Steel Structure America, AL-19-013

Please accept the following comments from El Paso County Public Health regarding the project referenced above:

SITE DEVELOPMENT PLAN
MONUMENT STEEL STRUCTURES
 SITE AND UTILITY PLAN
 18910 BASE CAMP ROAD
 MONUMENT, COLORADO

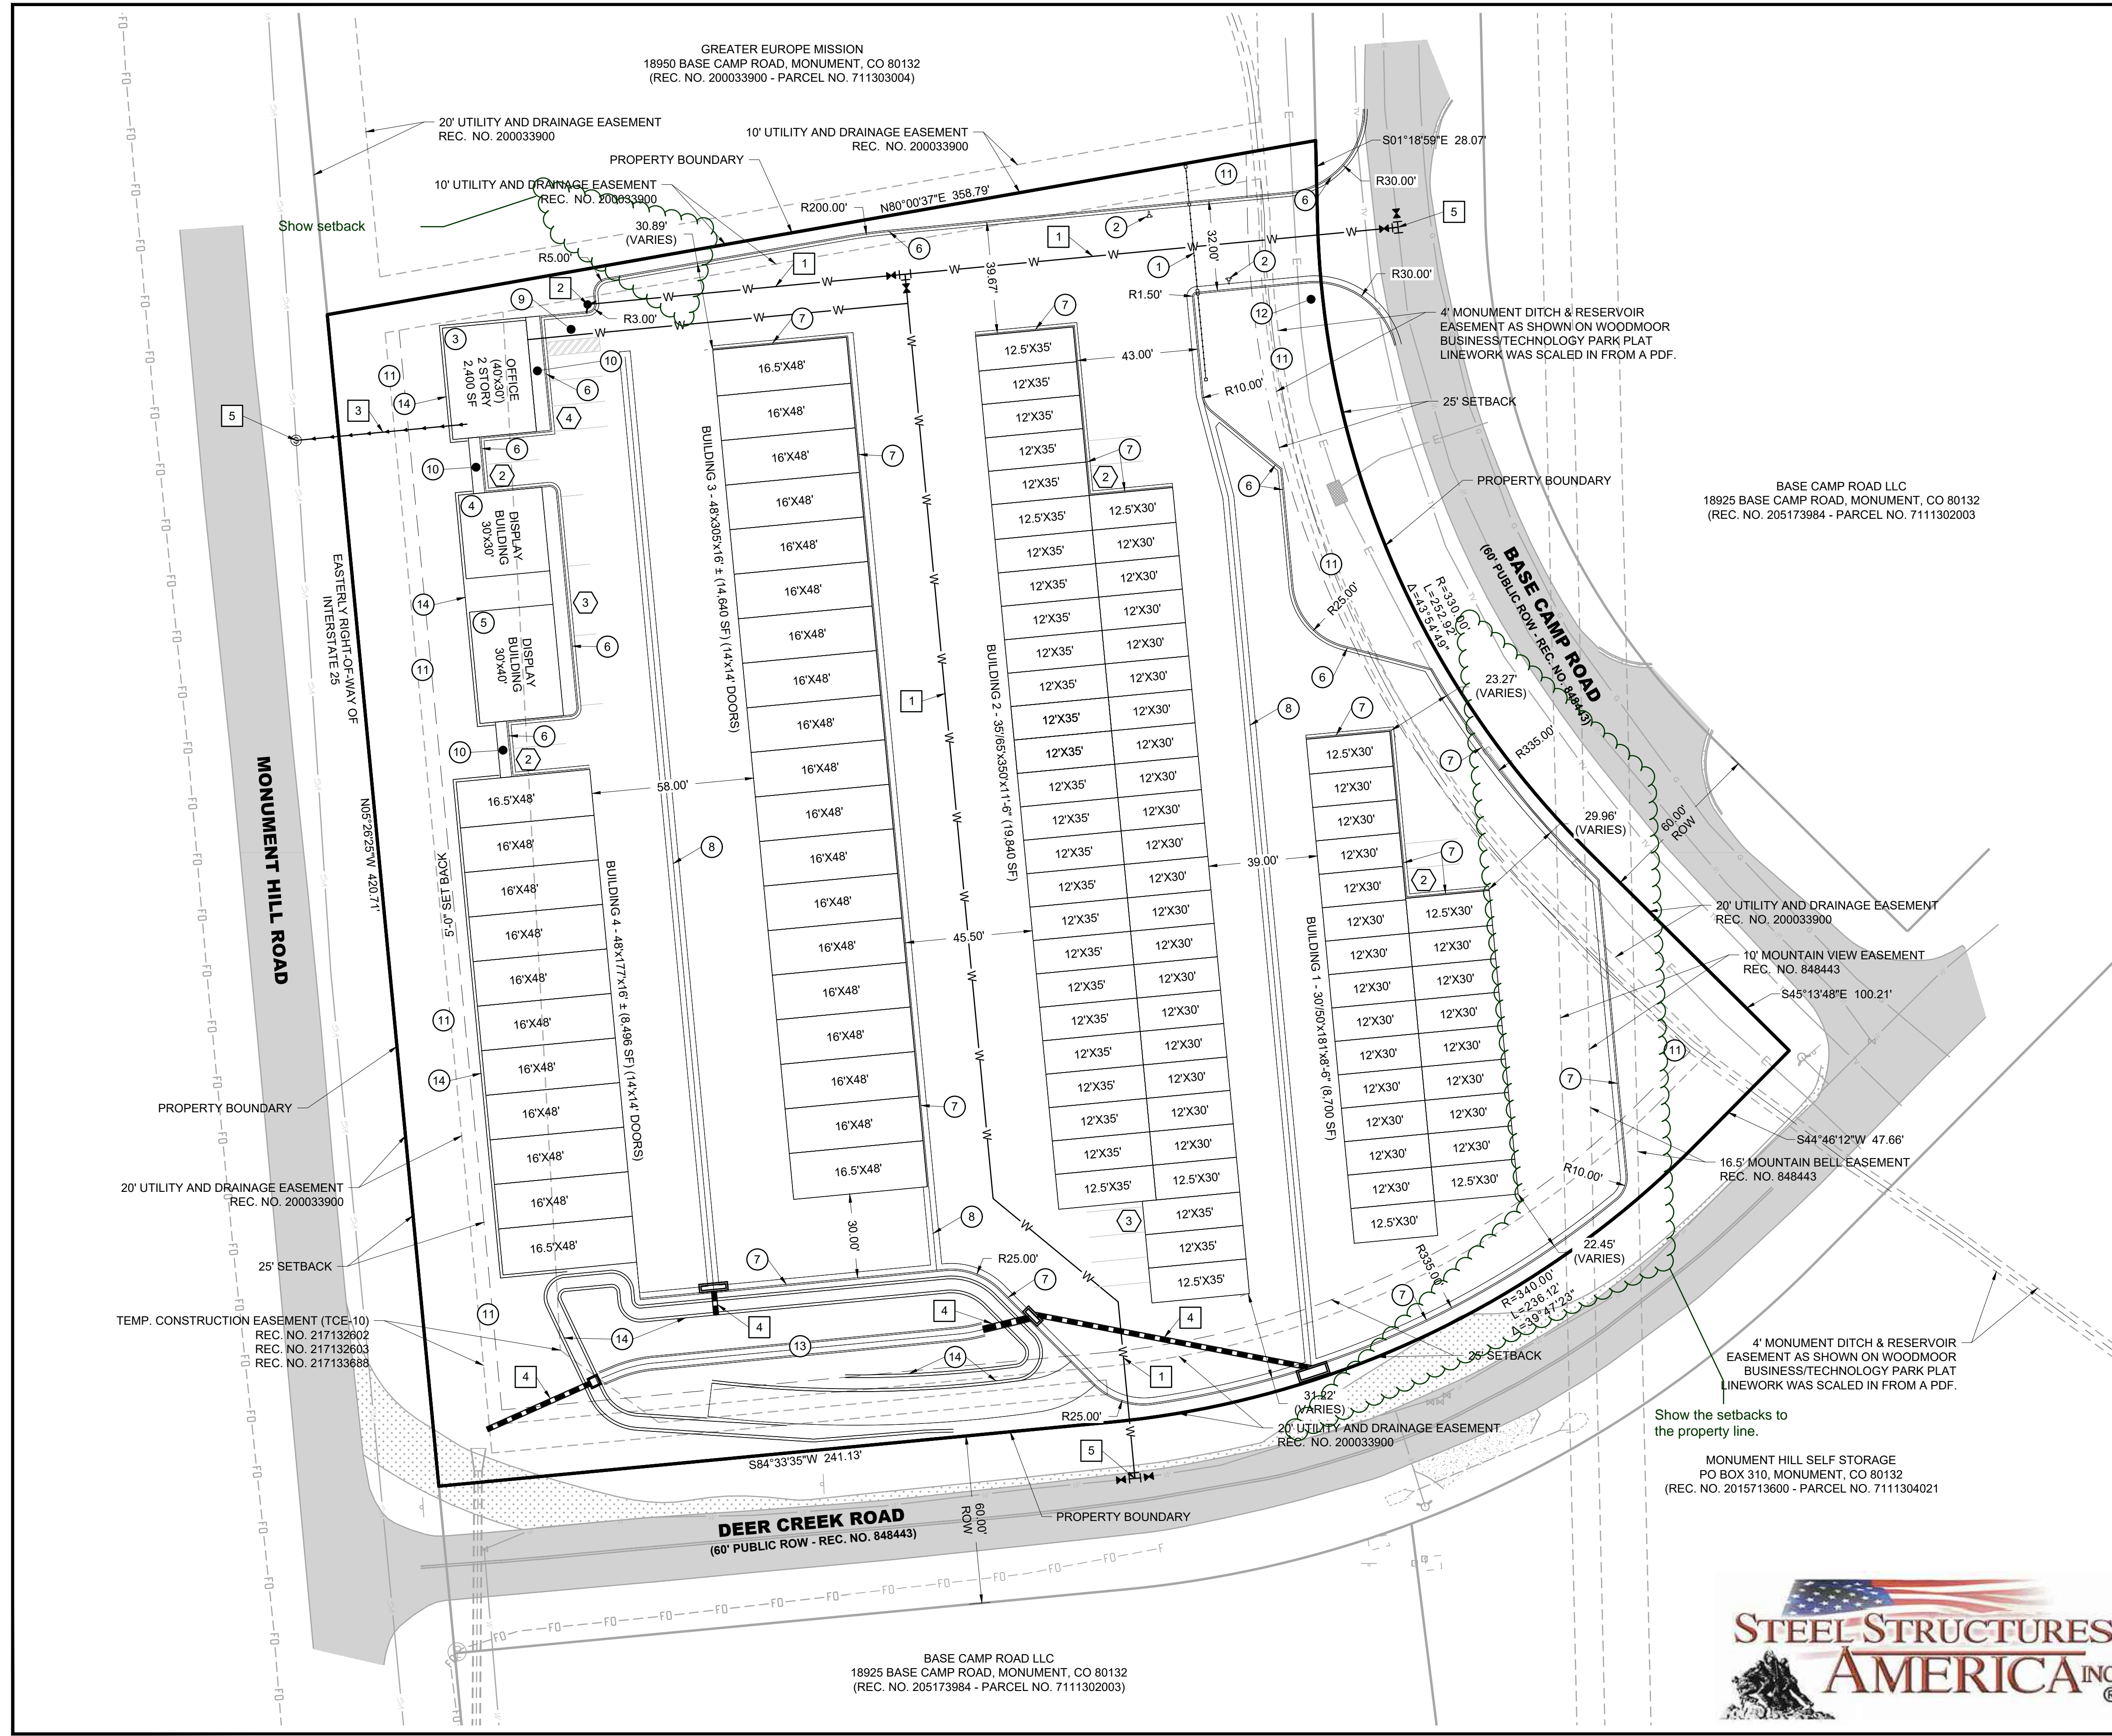
- The water quality basin must have mosquito control responsibilities included as a part of the construction design and maintenance plan to help control mosquito breeding habitat and minimize the potential for West Nile Virus.
